Recommendation Report for Planning Permission for Works or Extension to a Dwelling

REF NO: FP/11/21/HH

LOCATION: 1 Mornington Crescent
Felpham
PO22 8HL

PROPOSAL: Two storey side extension, single storey rear extension, porch to front and addition of 2 x parking spaces.

DRAWING	SCALE
PLANNING	1/100@A1
DATE:	NOVEMBER 2020
DRAWN:	T. Murray
DRAWING:	20/74/3
REVISION:

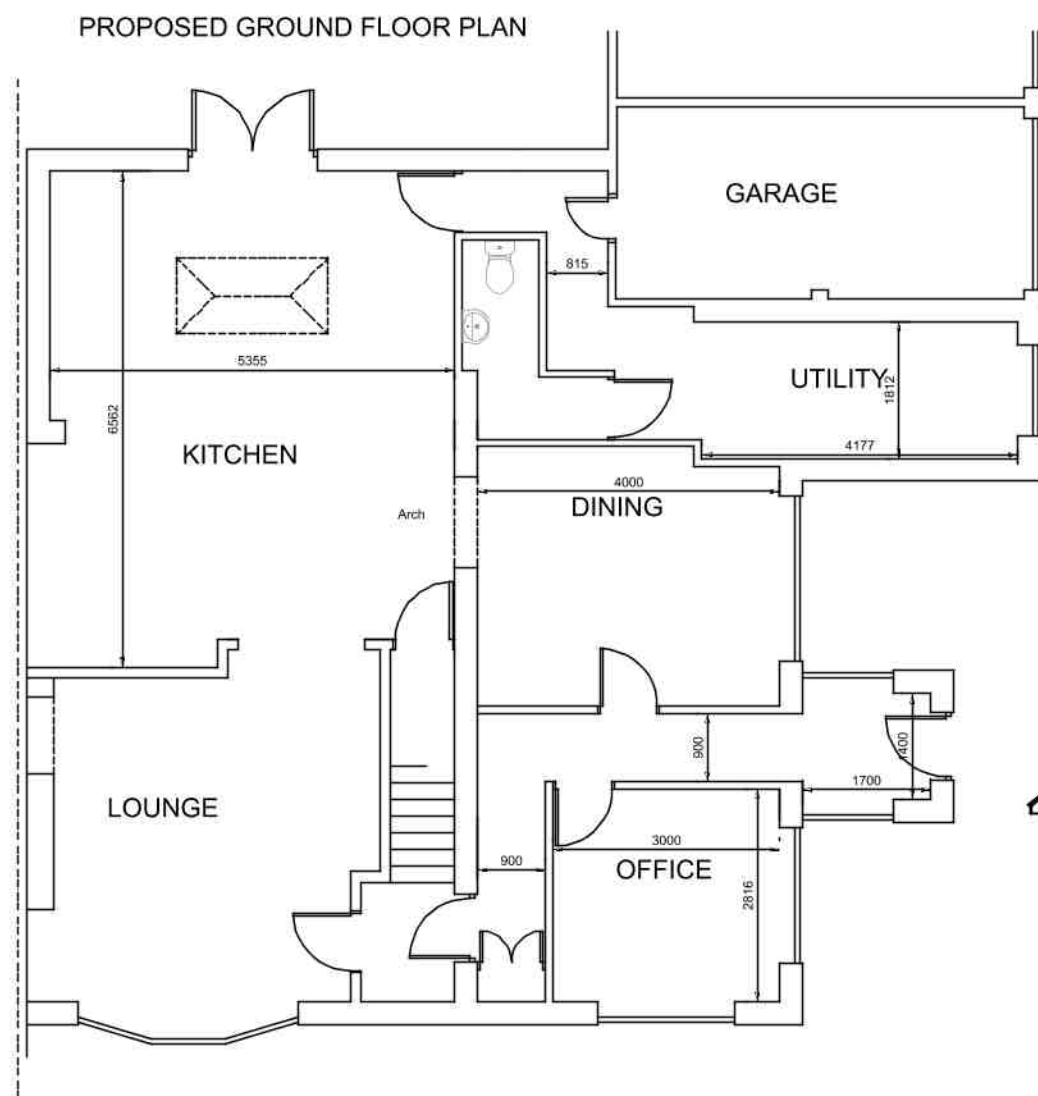
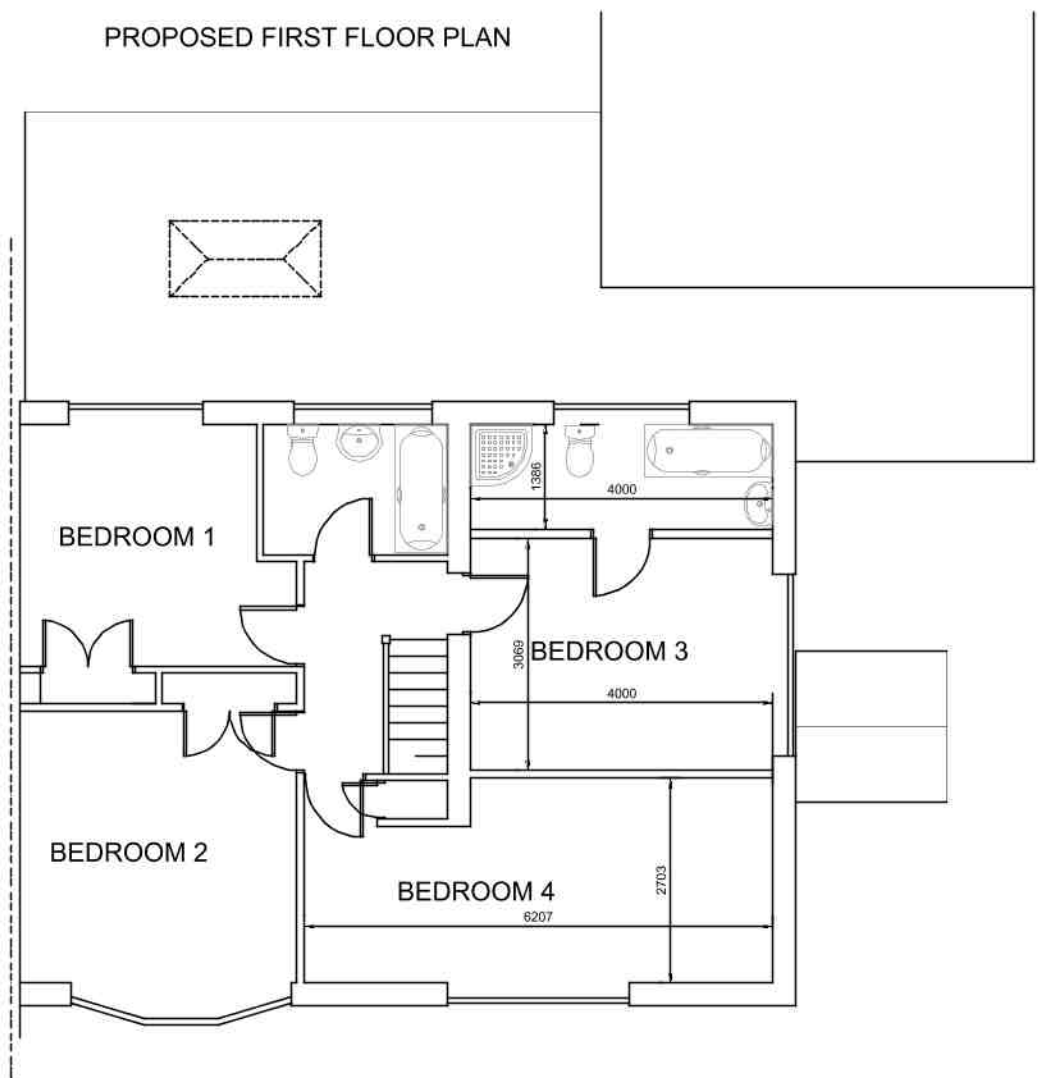
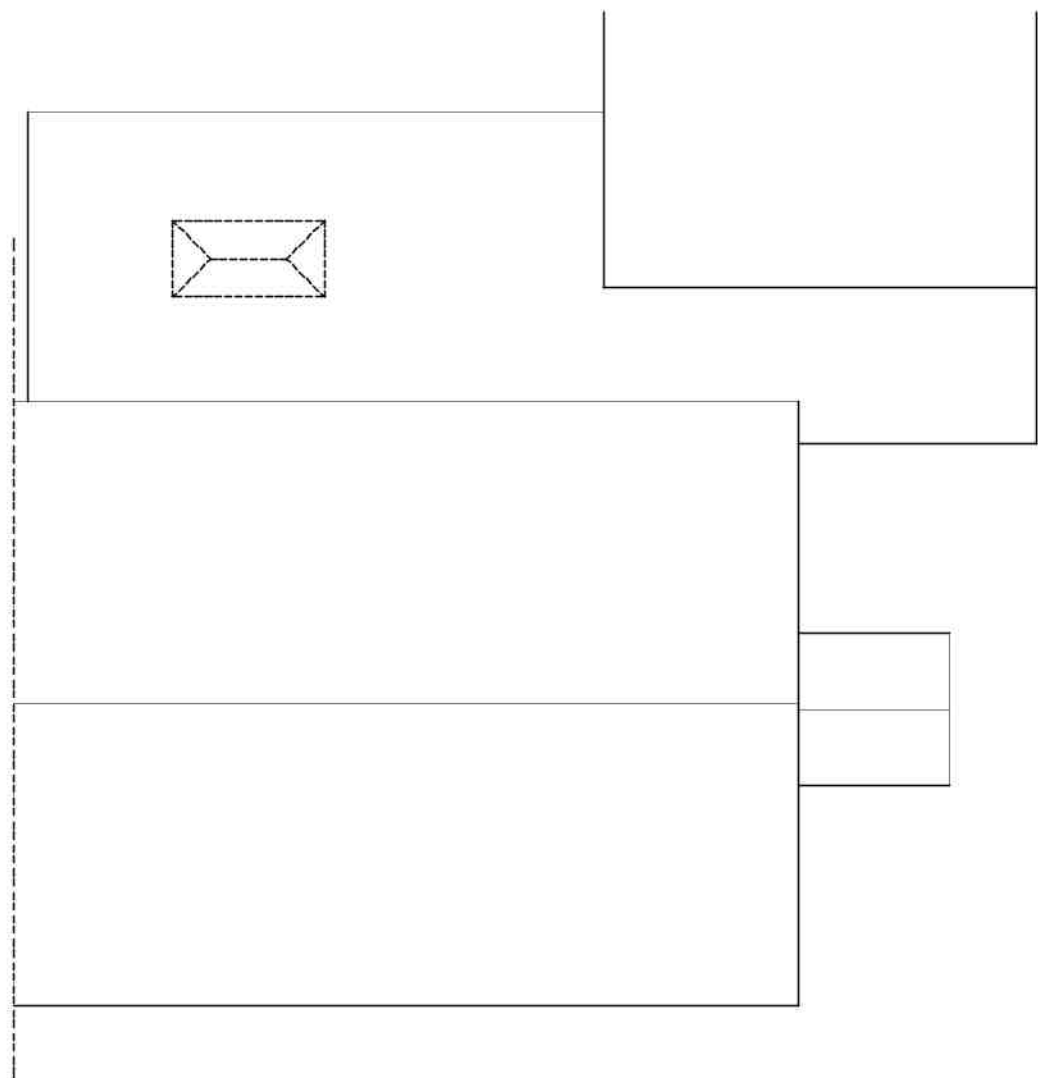
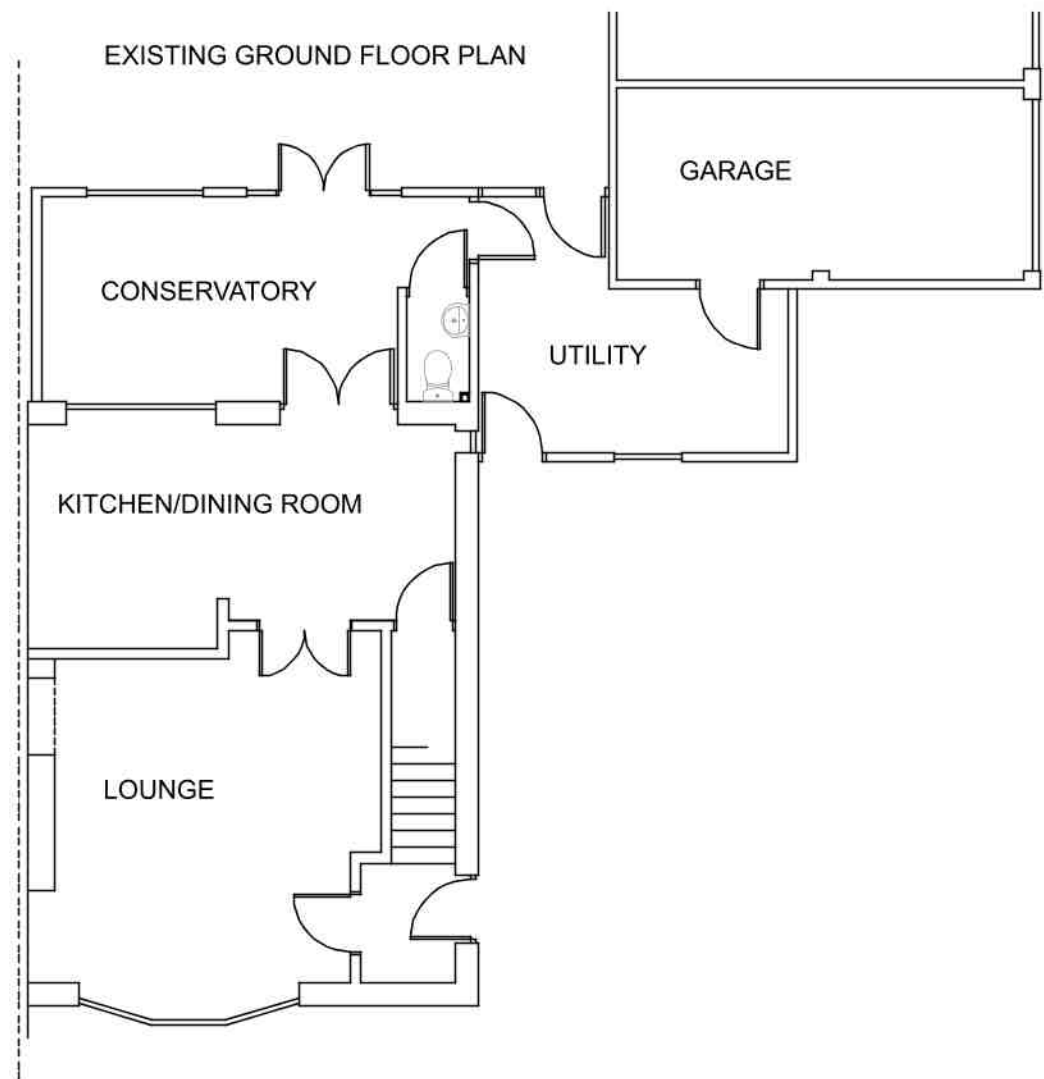
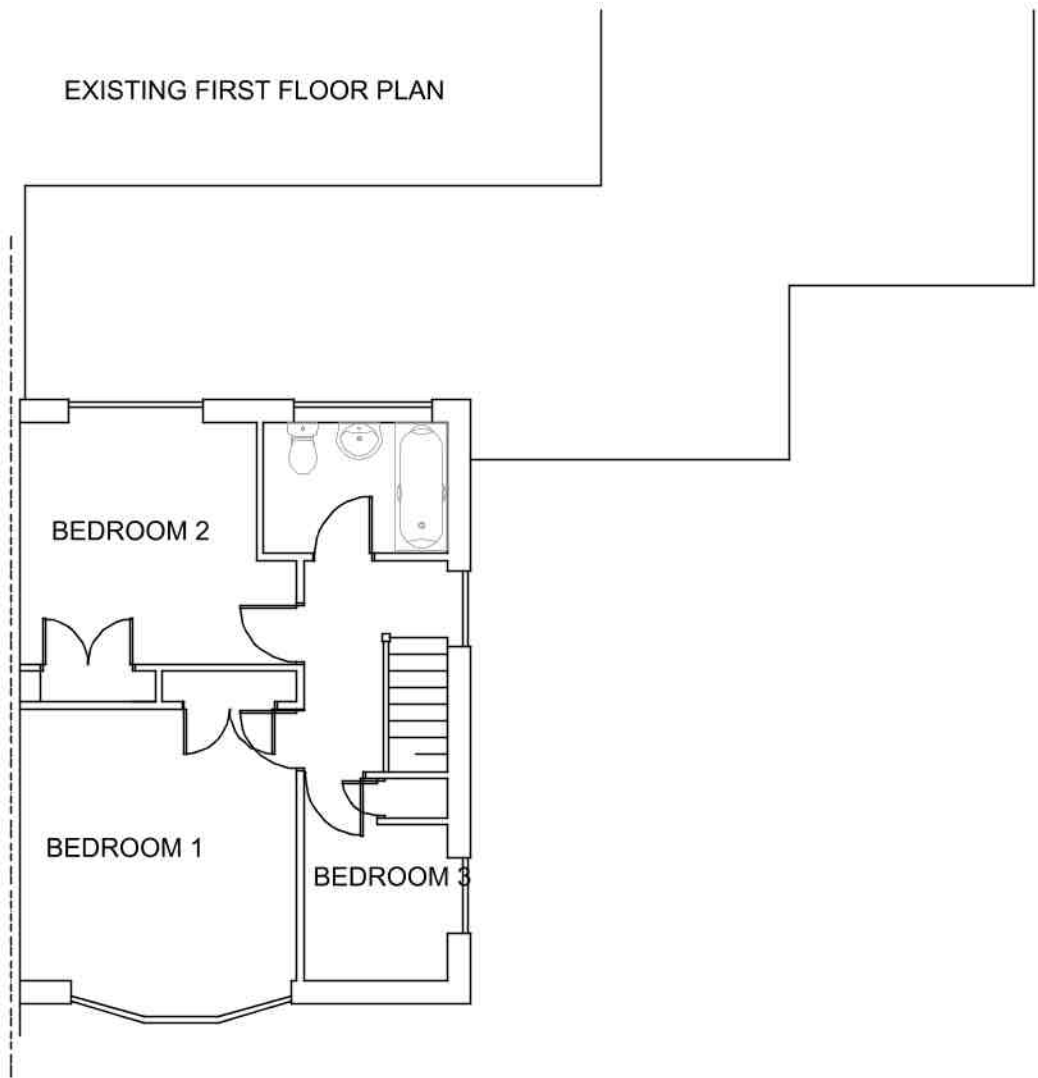
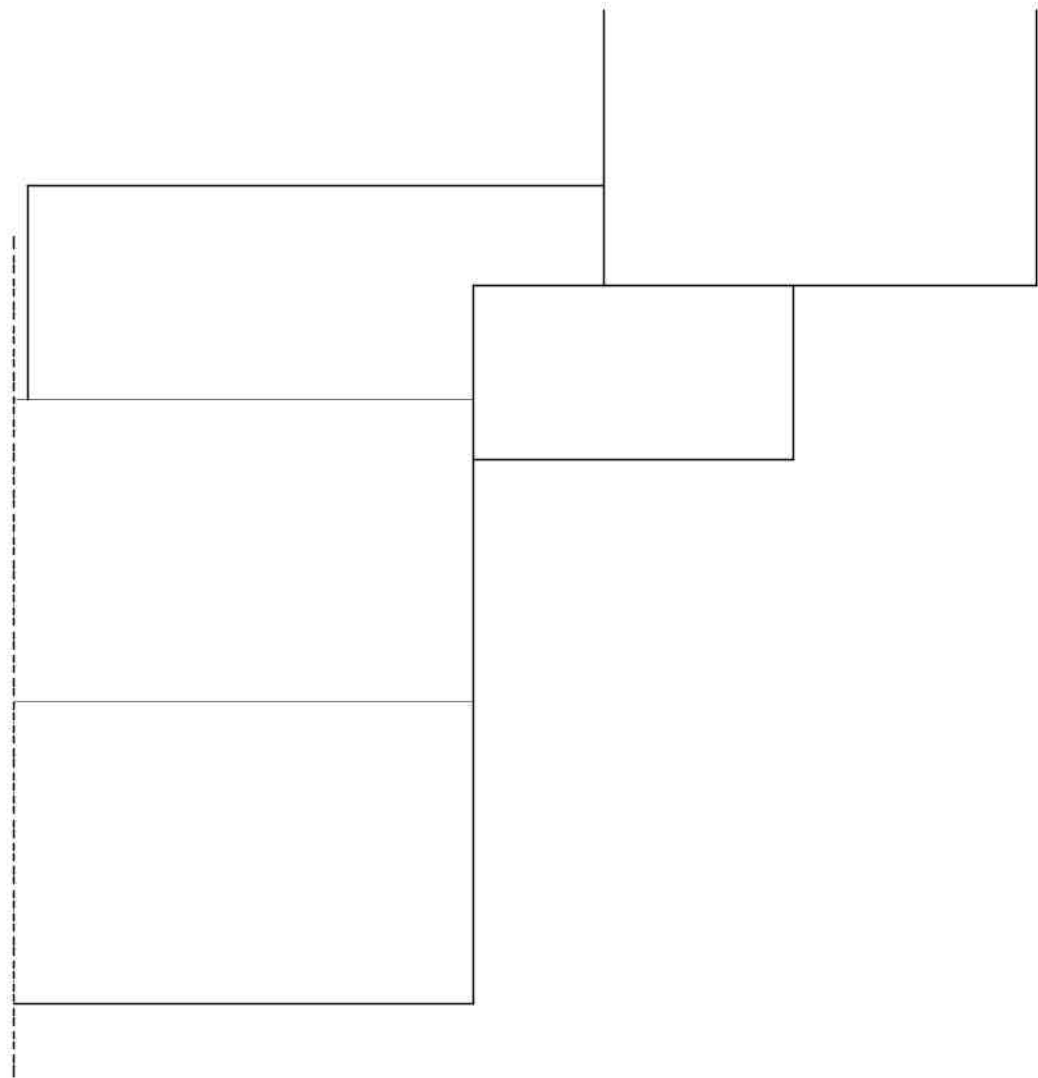
The side addition will be two storey in height and extend east. It will have a depth of approximately 4.3m which will encompass a grassed area to the side of the dwelling. There is also a single storey extension which will be extended slightly in depth and an existing utility to the side will be extended to will to meet with the front of an existing garage, which fronts the road to the east. This will have a depth of around 1.8m.

Due to the siting of the extension, it adds bulk to the side of the dwelling however retains a minimum of 2m to the eastern boundary as such it is not considered to appear unduly dominant in which a refusal is warranted.

The ridge line will be extended to match the host dwelling, this helps to ensure it appears well integrated.

There will also be a porch constructed to the front of the two storey addition with a further 1.7m in depth. It will have a pitched roof and is modest in size.

To the rear there is an existing conservatory which will be removed and replaced with an extension which will extend along the rear. The extension will have a maximum depth of around 3.7m. This is around 1m further than the existing rear. It will have a height of 2.85m. The rear extension is considered to intersect a 45 degree angle when a line is drawn from the centre of the ground floor rear window closest to the

shared boundary. However, with a modest height and the depth only slightly larger than that which can be constructed under permitted development, it is not considered to result in a significant impact upon amenity in which a refusal is justified and the existing conservatory is likely to result in the same impact.

The development will feature a number of additional windows. There will be 2 windows to the south and 3 to the east which will have views over the street scene. There will also be an additional first floor window to the rear. Due to the siting, this would look towards the property at the side/rear which is a bungalow and whilst it does not provide direct views into the property it may provide additional views into the garden and it will be conditioned the window is to remain obscured glazed.

- 4 The first floor window on the northern elevation of the building shall at all times be glazed with obscured glass and only openable at a high level, at least 1.7m above finished floor level.
